**Planning and Urban Development Department
Planning Division**

RE: Comments for Proposed Development – Level III Review

Project:	Building Conversion	Project ID:	2018-011
Project Address:	415 Cumberland Ave.	CBL:	36-G-33
Applicant:	Sam Reiche		
Planner:	Christian Roadman

**A2.01**

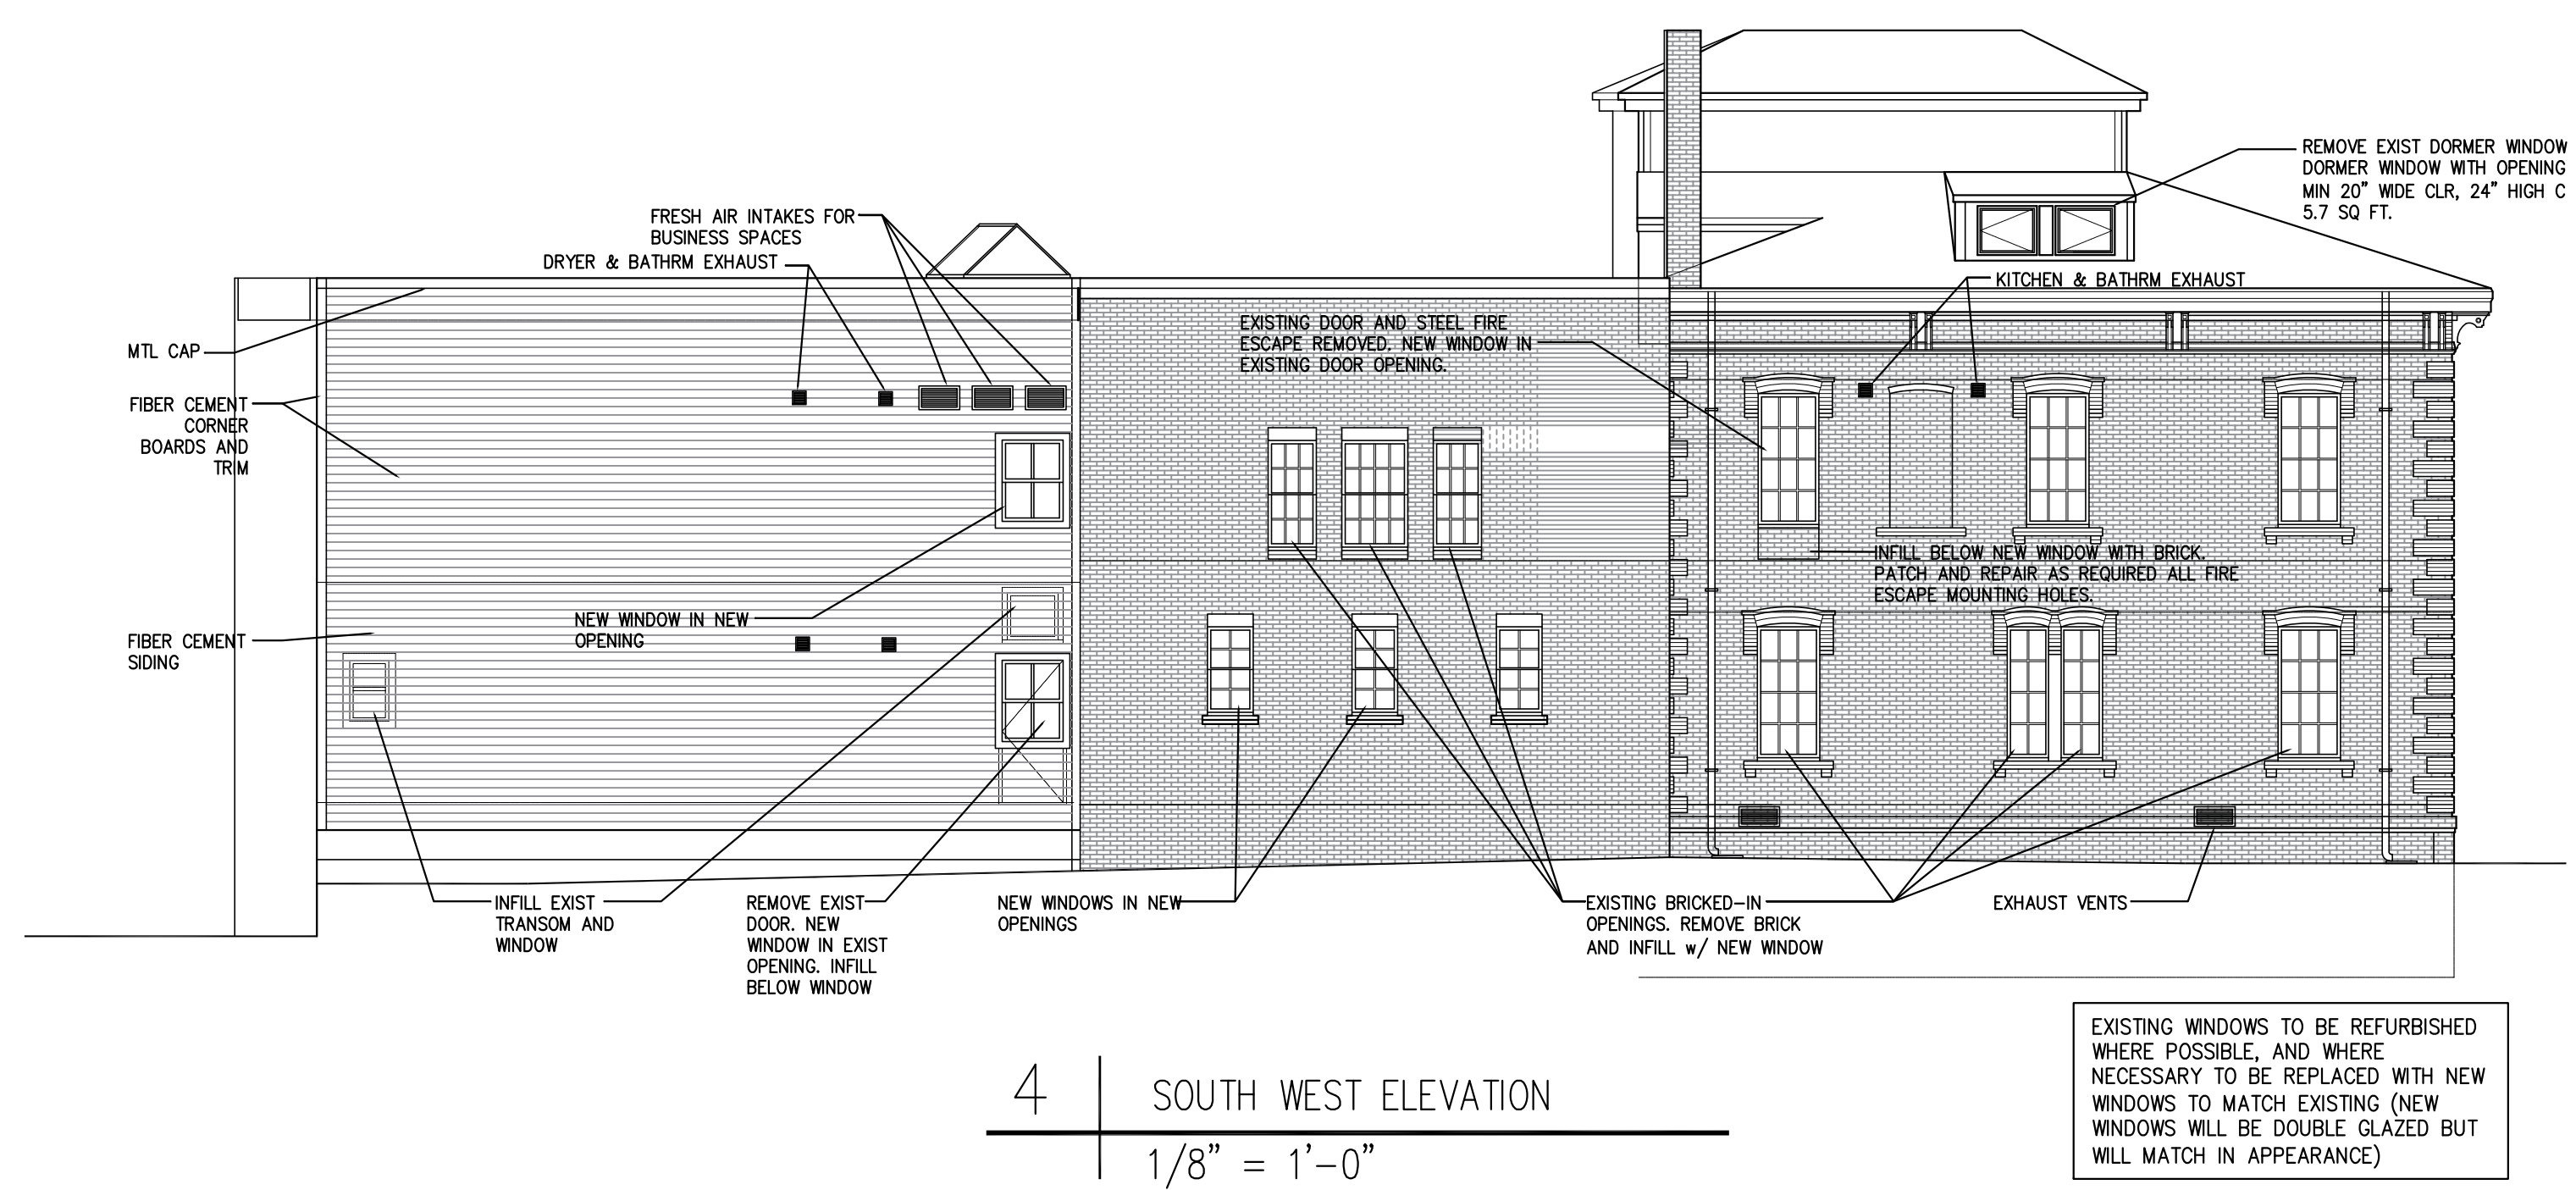
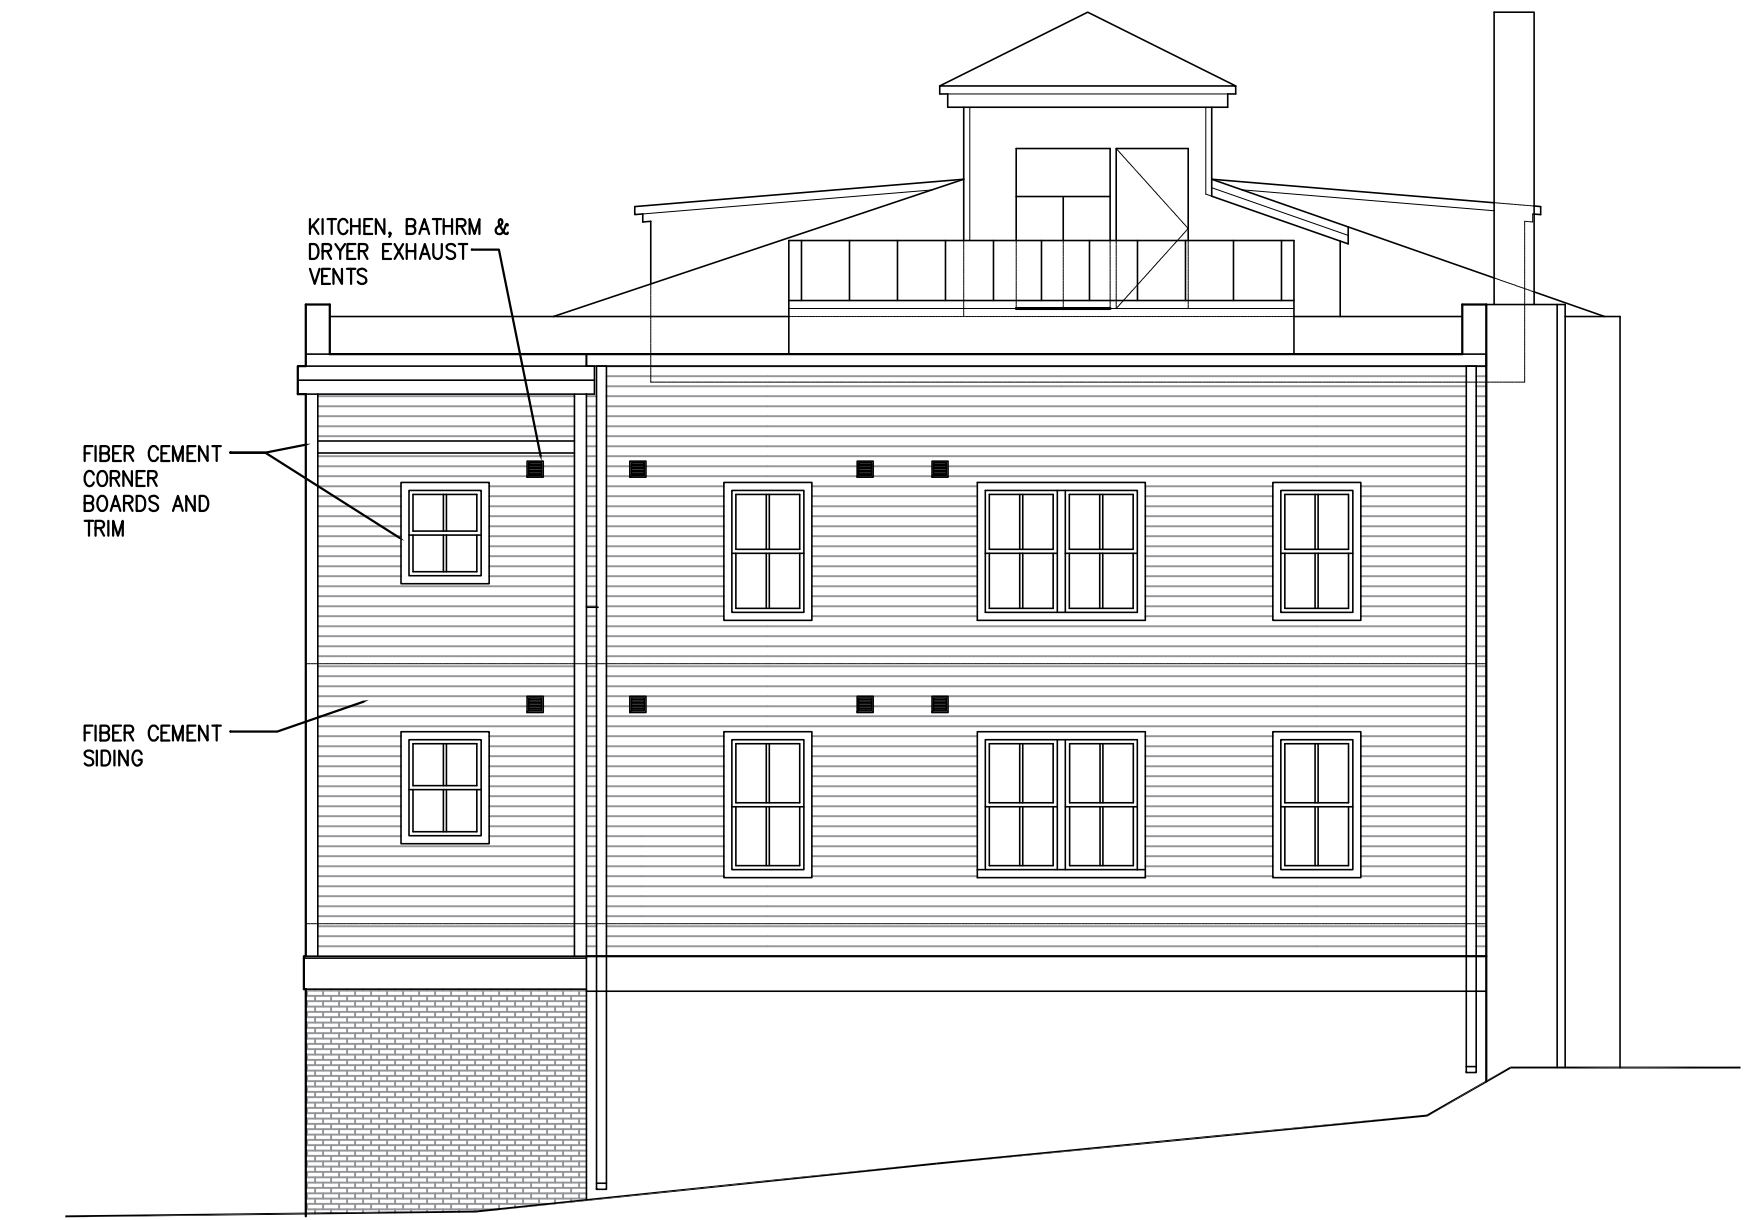
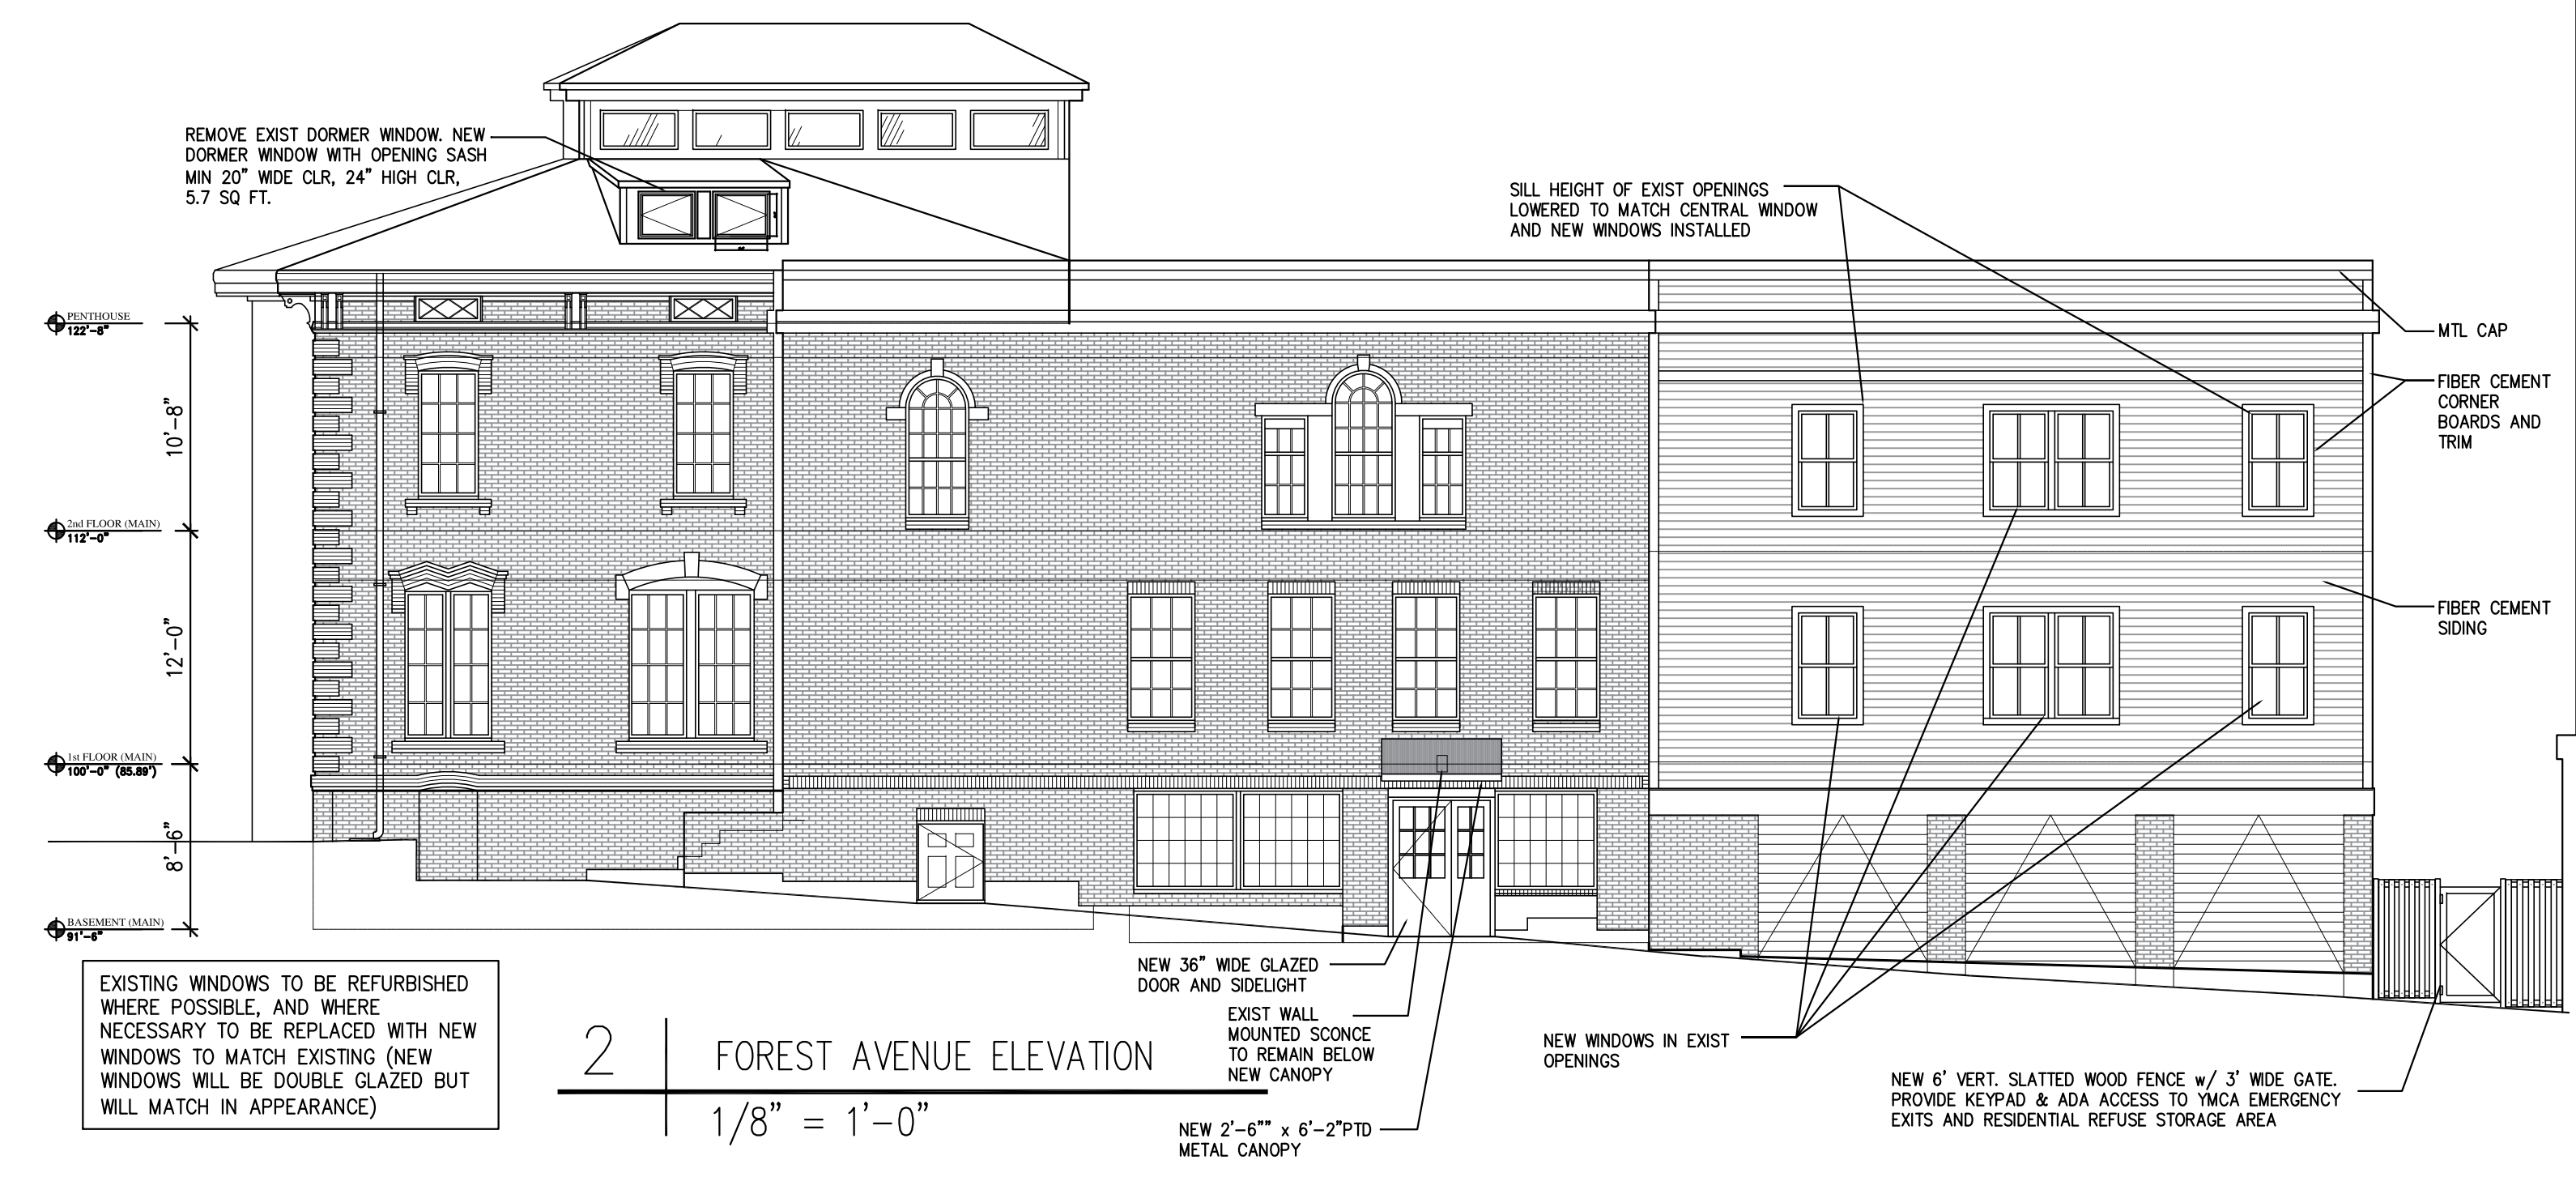
11. Please provide details on new windows. What are the materials? Windows should feature simulated divided lites with applied exterior muntins, at a minimum. Also, please identify which windows will be repaired and which will be replaced.

12. Please provide details regarding window moldings: will brick moldings be replicated in aluminum trim on other, new windows?
13. Why are two windows on the northwest elevation a different height than all other windows on that elevation and the Forest Avenue elevation? Ideally these will all match.

15. Please provide details regarding finishes. The painted finish of Hardie plank should not be high contrast, nor should the relationship of trim to the body of the building be high contrast.

16. Please specify the reveal / ttw of the Hardie plank. It should be less than 6.”
17. Hardie plank shall be installed smooth side out. Please note this on plans.

18. Exhaust vents shall be painted to match the surrounding material (brick or Hardie plank siding). Please note this on plans.
19. Hardie plank at the top of the building parapets on the Forest Avenue and southwest elevations seems strange – the treatments / bands along the top of the building’s middle section should be continued.

20. Please identify if garage doors will be replaced. If so, materials and details must be specified.
21. Please provide details regarding the proposed new door on Forest Avenue, especially regarding material and panelization.

22. The coal chute on the Forest Avenue elevation shall be retained, not removed or covered. Please show this on plans.
